Crime Impact Statement

Planning Application 3/2017/0183 – Reserved matters (following outline 3/2014/0183 Kirk Mill) for residential development of 41 dwellings including appearance, landscaping, layout and scale at Land Adj. Church Raik, Chipping (Land Parcel 3).

The proposal is for 41 no. dwellings (reduced from 56) comprising a mix of dwelling types (7) and 9 no. designated as two bedroom affordable units (including one bungalow) as 4 no. ground floor and 4 no. first floor apartments with car parking.

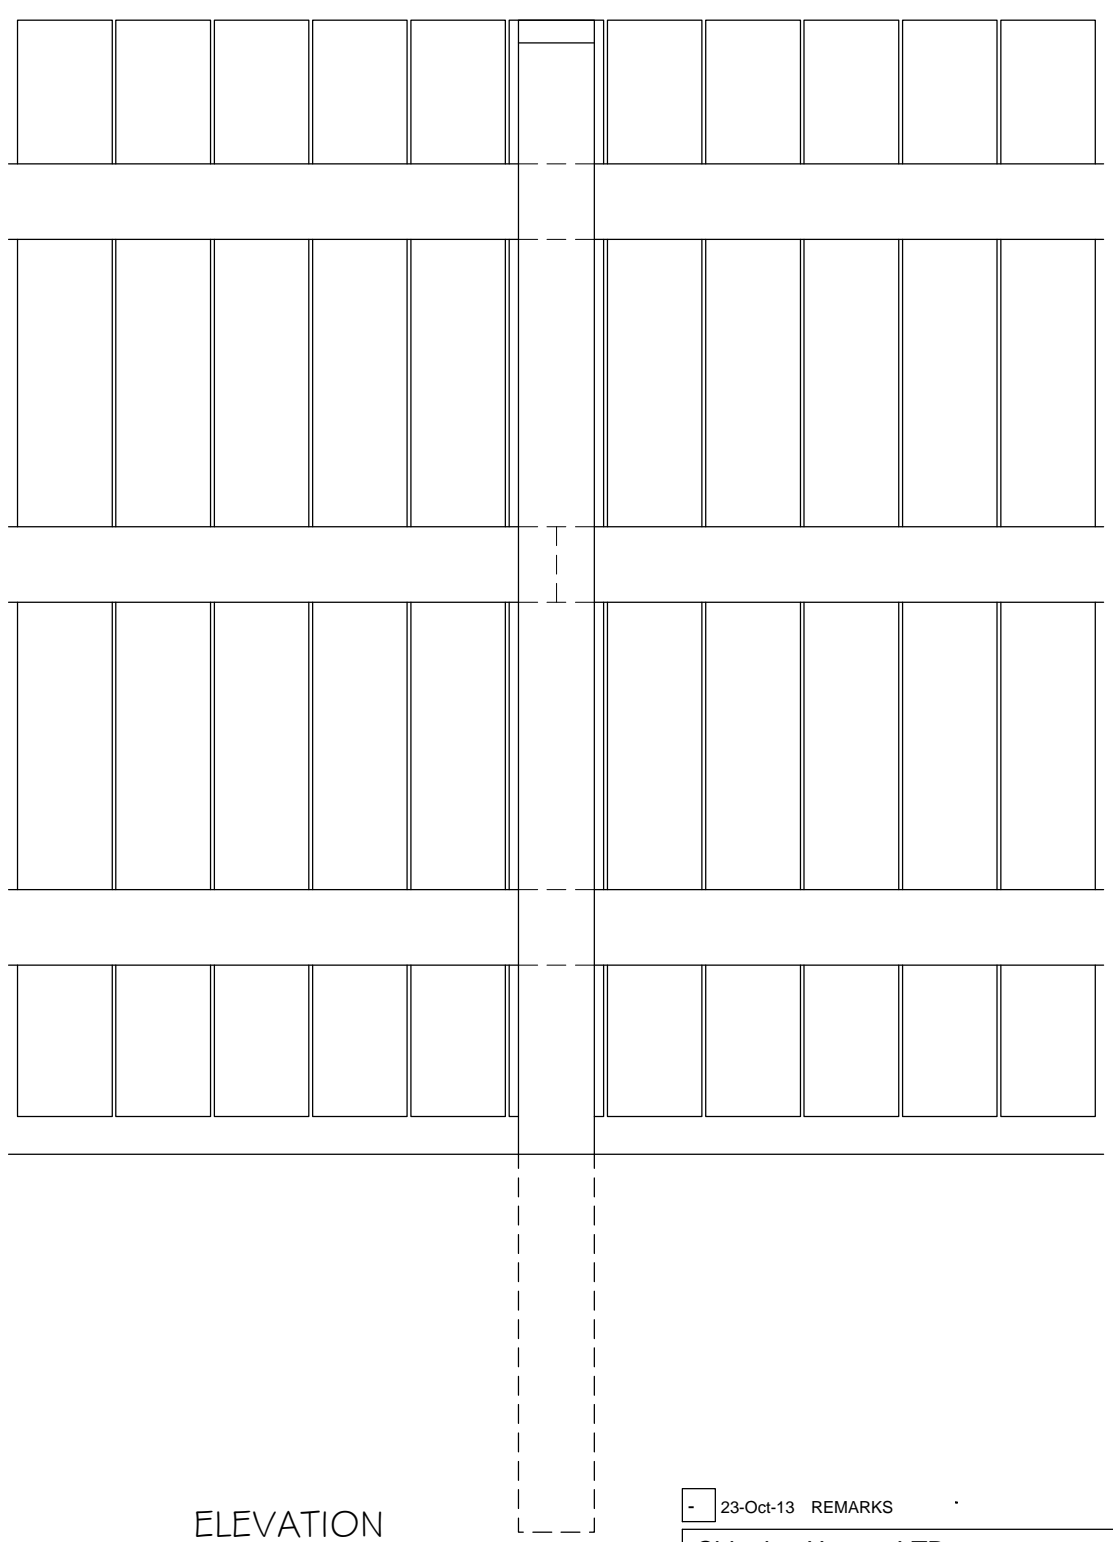
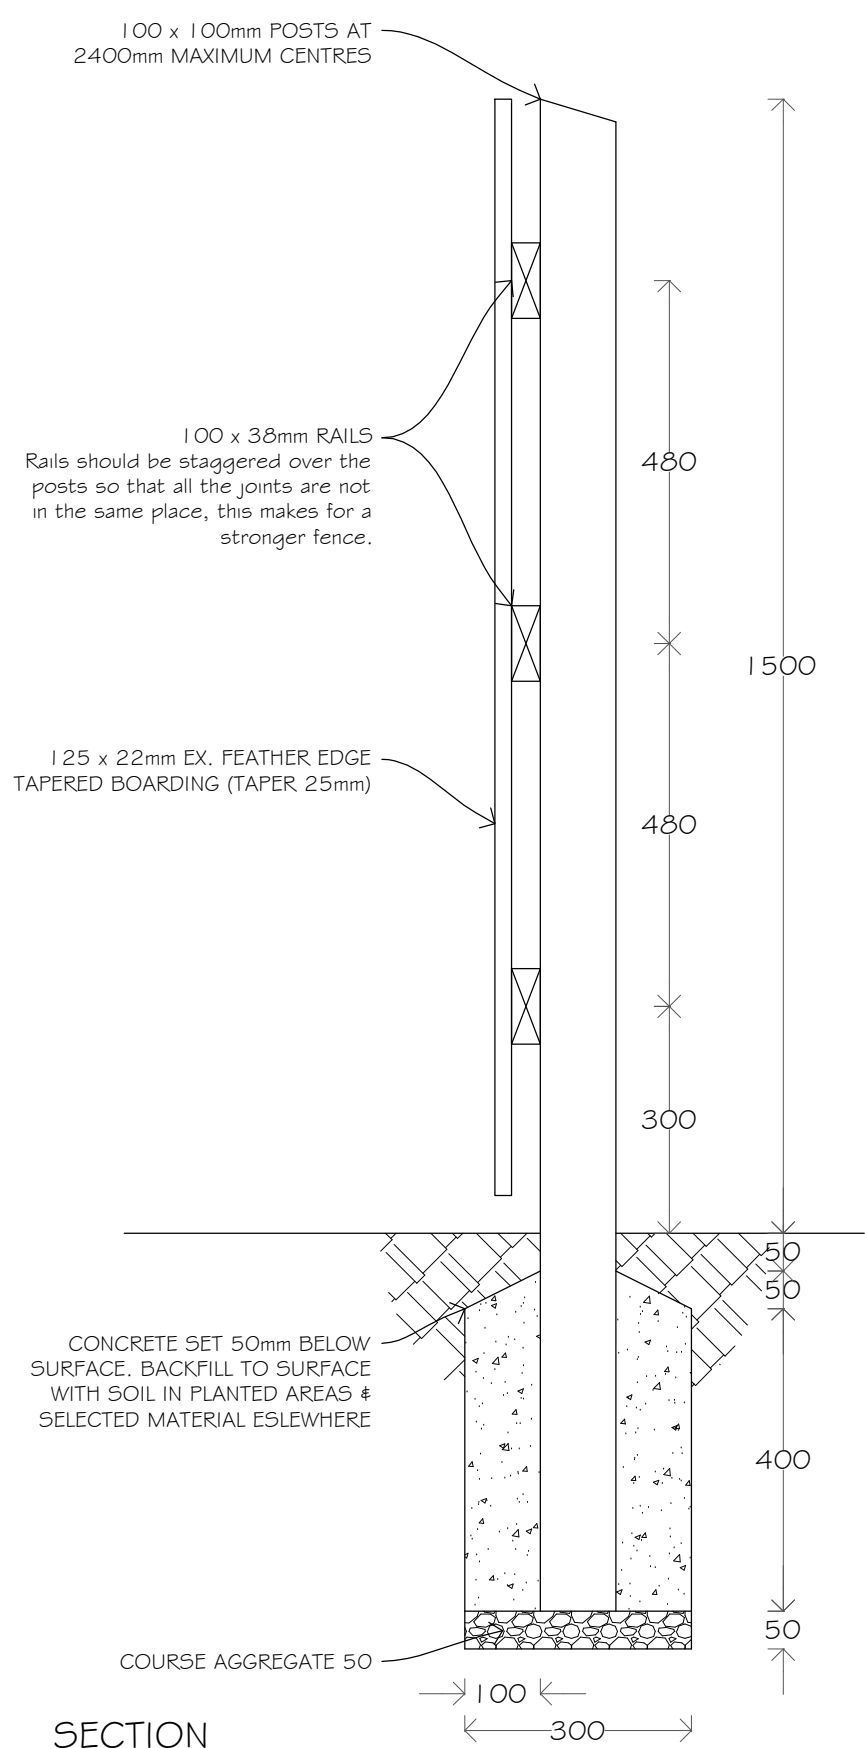
- Boundary treatments should be sufficient height and design to deter intruders. A height of 1.8m close boarded fencing is usually suitable for the perimeter of rear gardens with dividing fences reducing to 1.5m, if preferred.

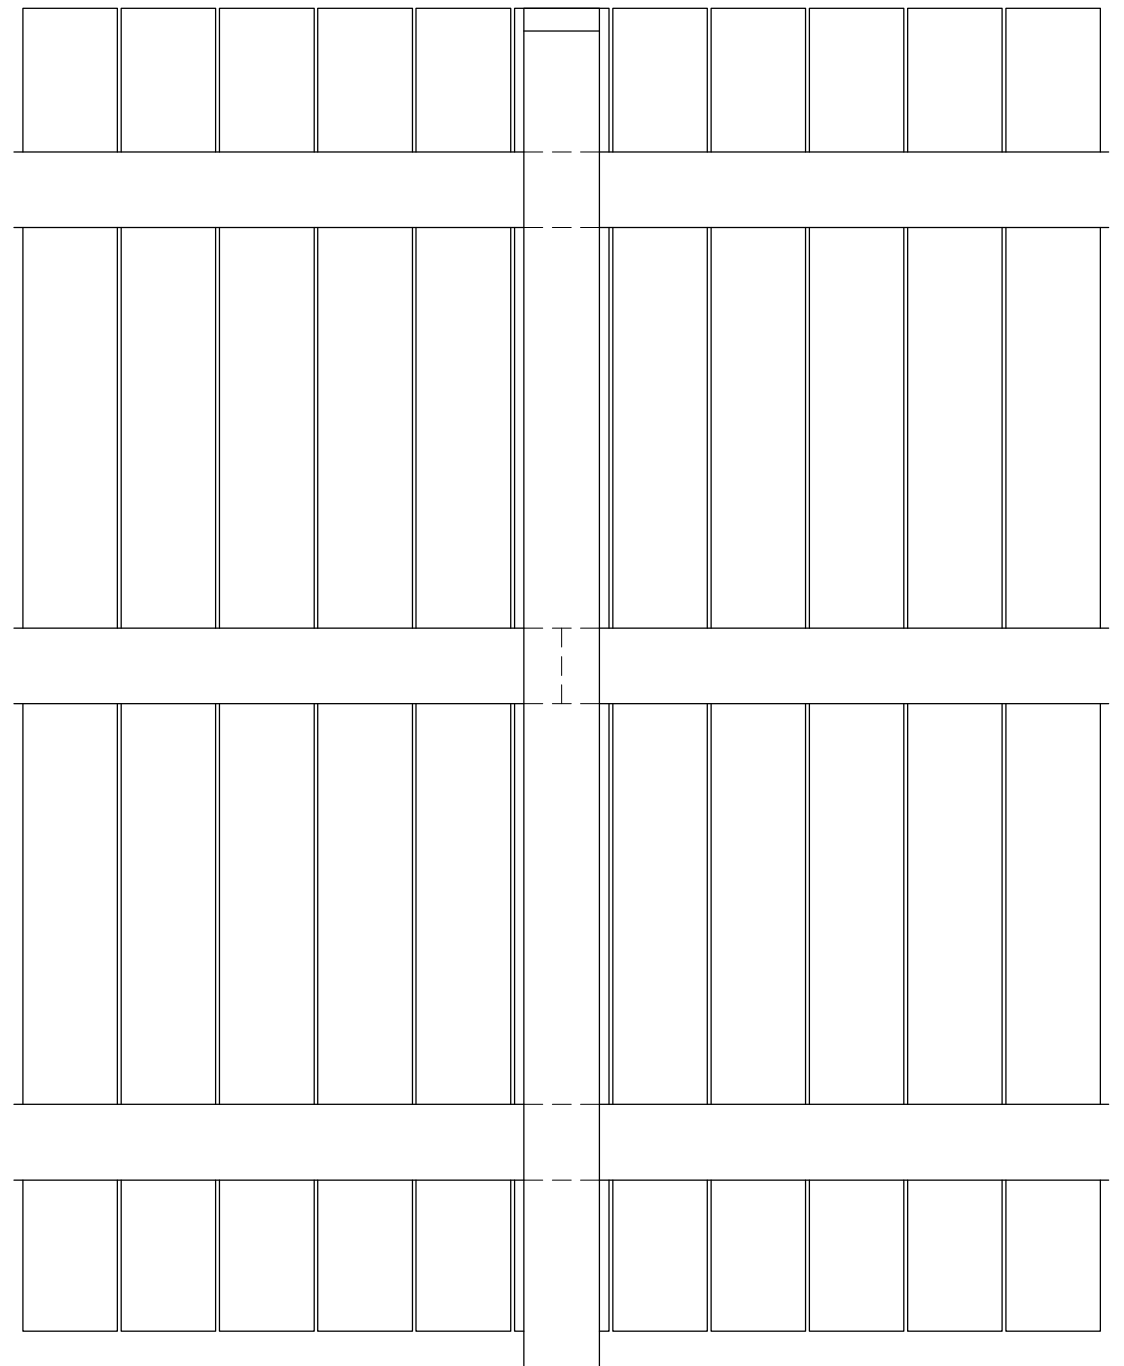
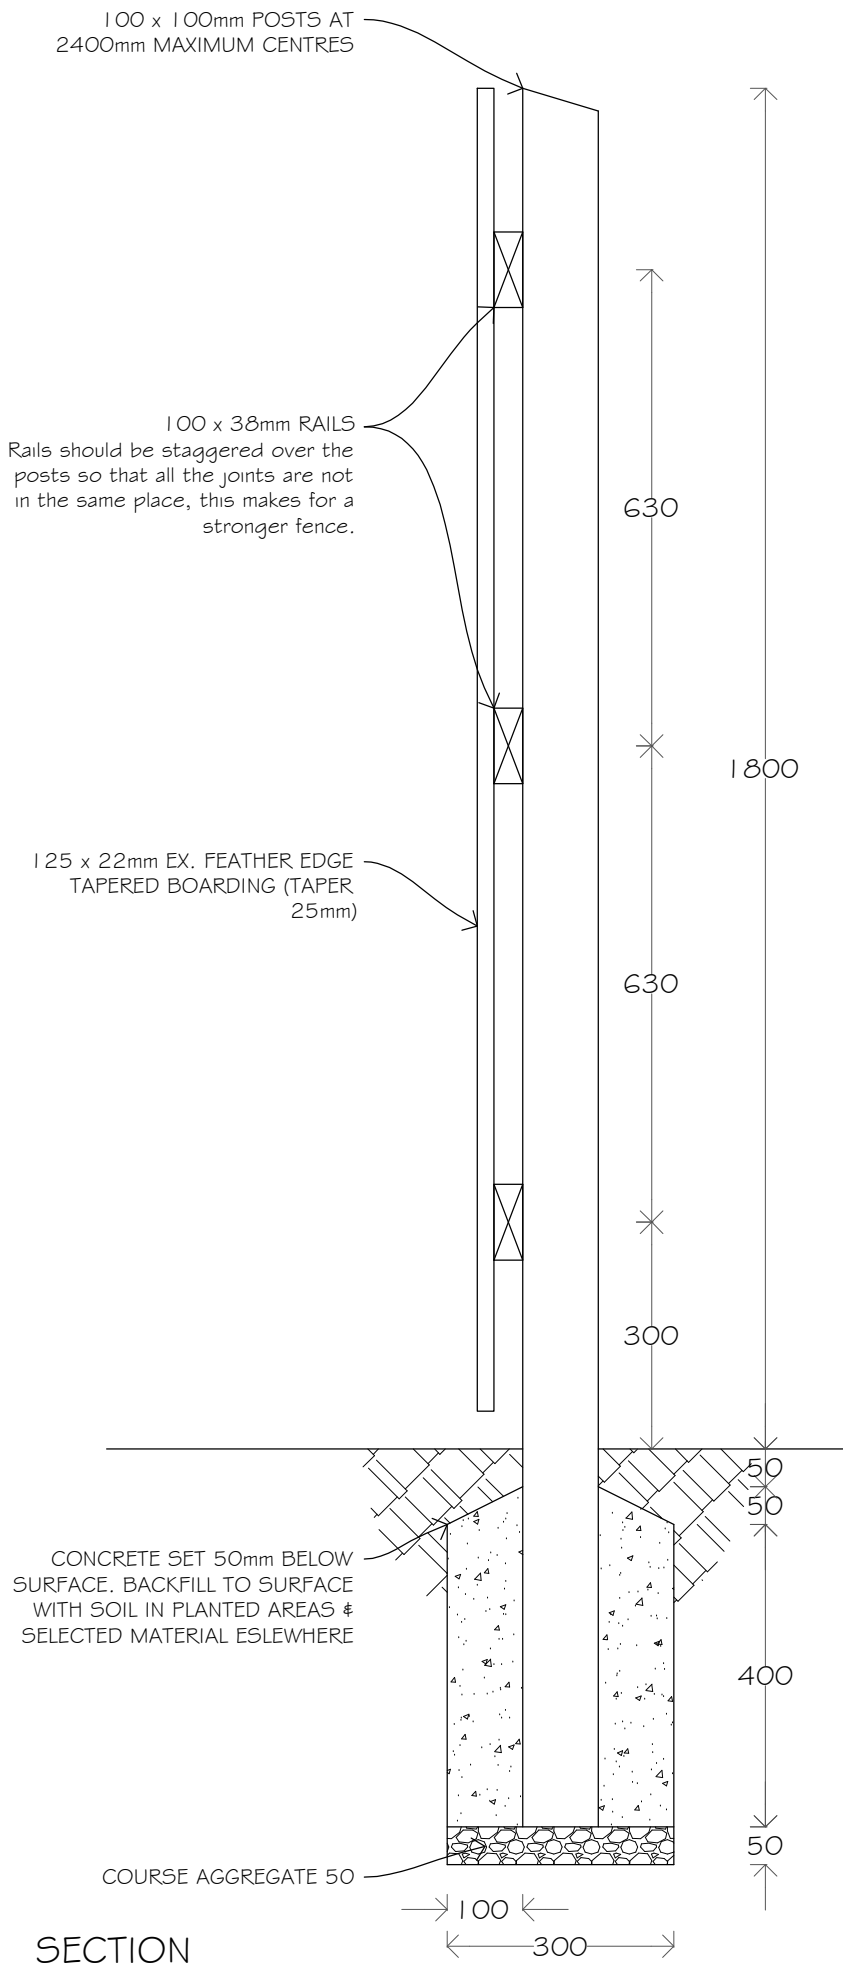
- The proposal for some of the car parking provision relating to the 9 no. affordable dwellings is of concern in terms of vulnerability as natural surveillance would be limited, especially for plot 6 and parking spaces adjacent to plots 13 & 14. As an alternative for Plot 6, the height of the proposed rear 1.8m close boarded fencing could be replaced with 1.5m high close boarded fencing with a trellis top taking it up to 1.8m. This would increase natural surveillance of the parking spaces by the occupants.

Typical Garage Overview

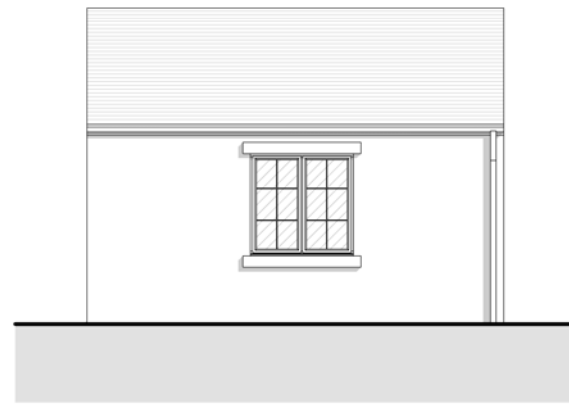
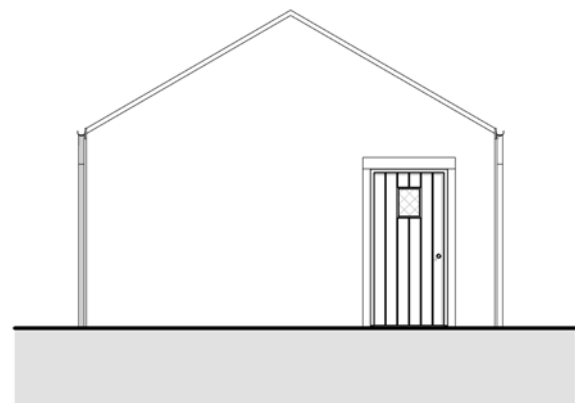
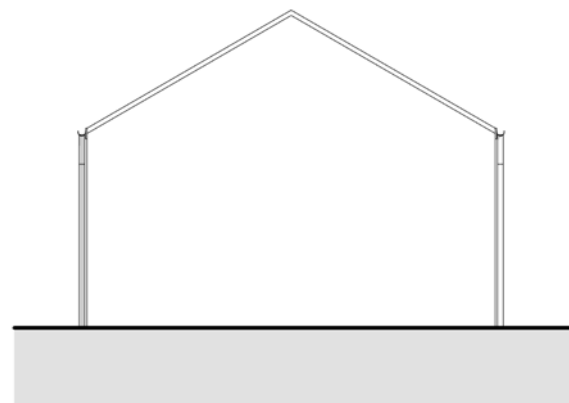
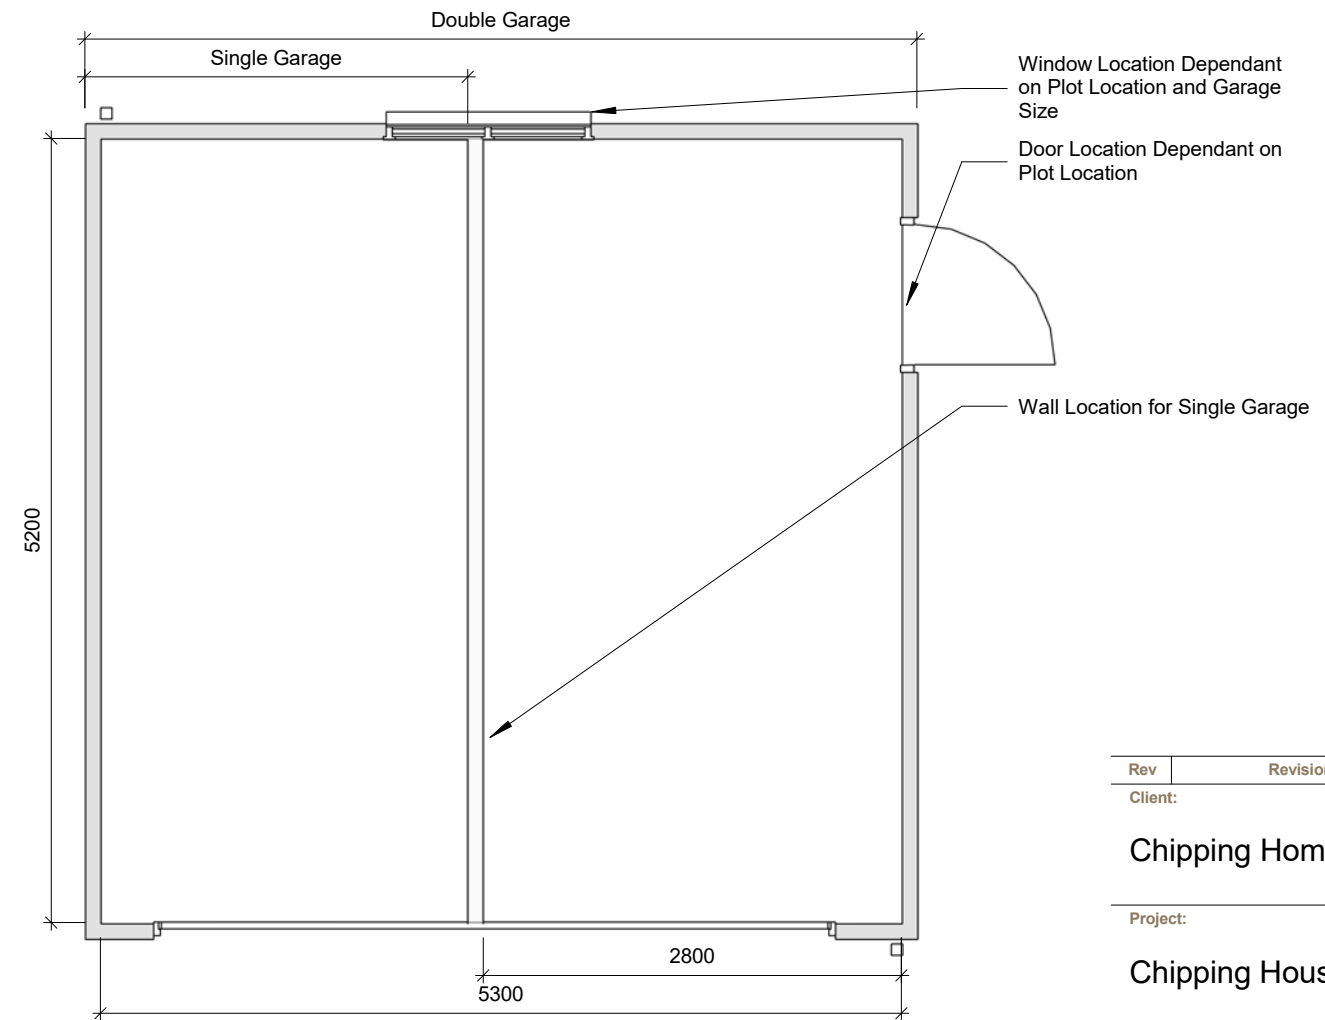
- Utility meters should be located as close to the front elevation as possible so access into secure/private areas is not required to read the meters.
- Garages and sheds should not have windows as they provide a view of valuables stored inside.
